Application no: H01-0023-12

Description: Proposed garage/implement store (for domestic purposes) and change of use of agricultural land to residential

Amendment: Reduced length of building
(Dwg. nos. 2358-11/01C and 2358-11/04)

ACKNOWLEDGEMENT OF AMENDMENT

AMENDED PLAN

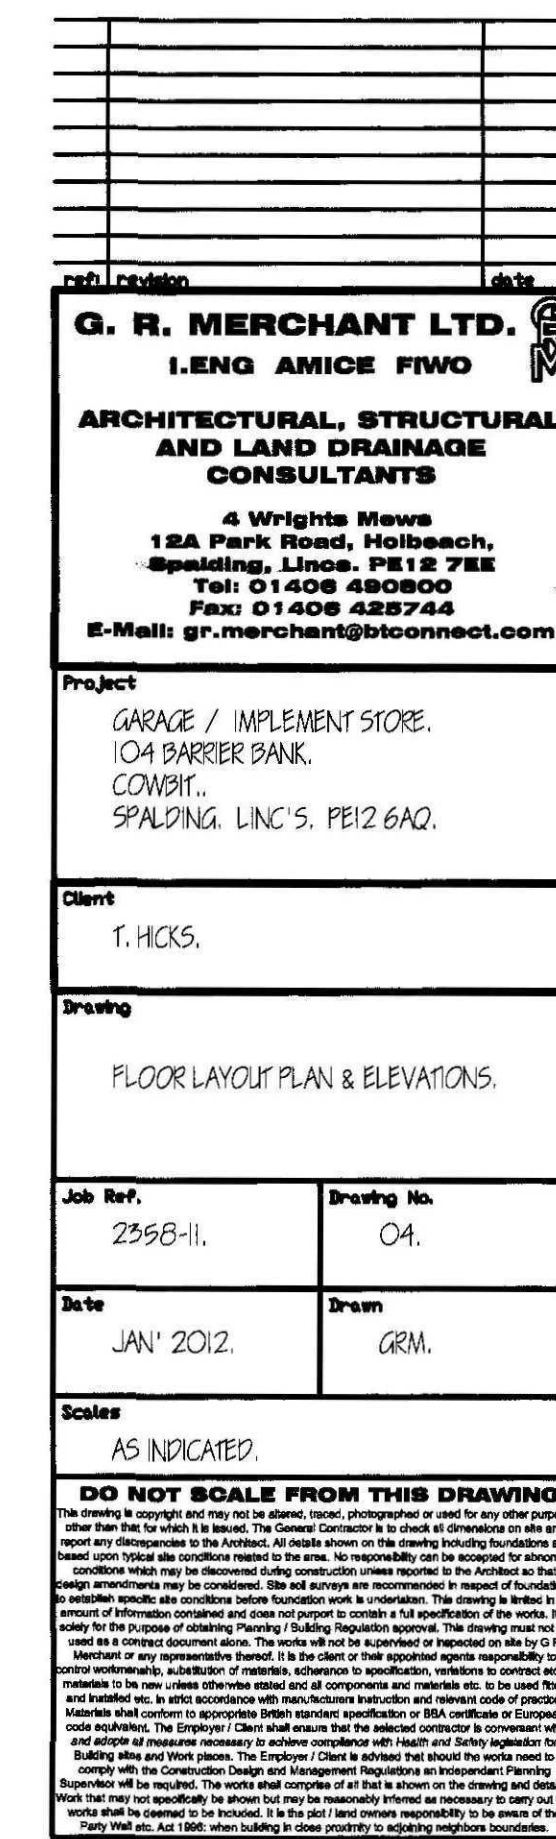
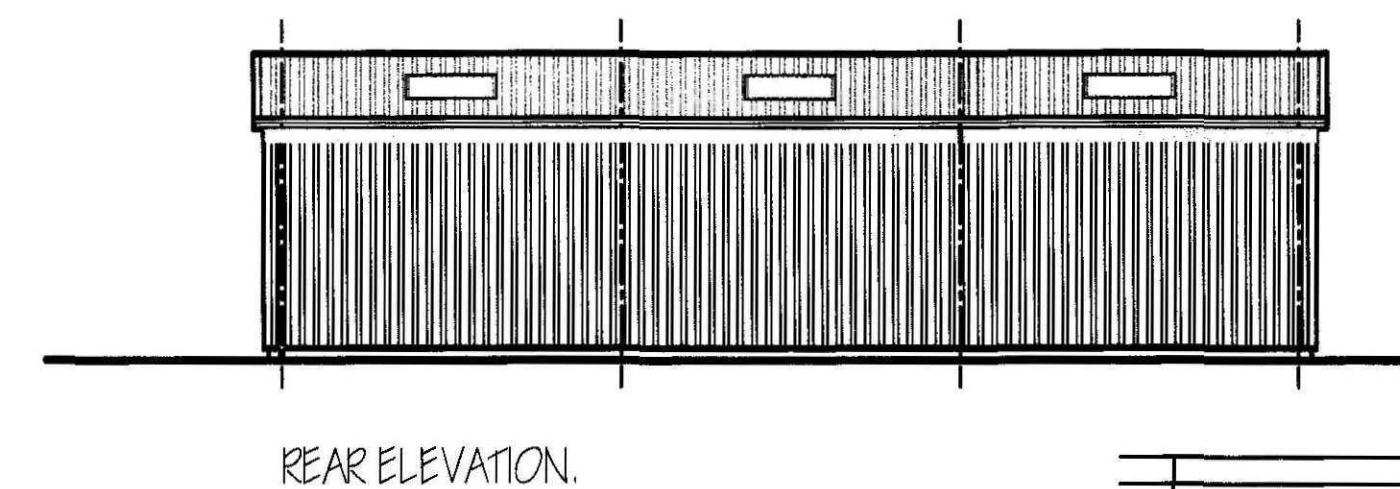
- I have reduced the length of the building, as suggested.
- The original position of the building is preferable, discussions have taken place with the neighbours, it is also there preference.
- You mention a container, in our conversation, this currently house his lawn mowers and general gardening equipment and will be removed when the proposed building is completed.
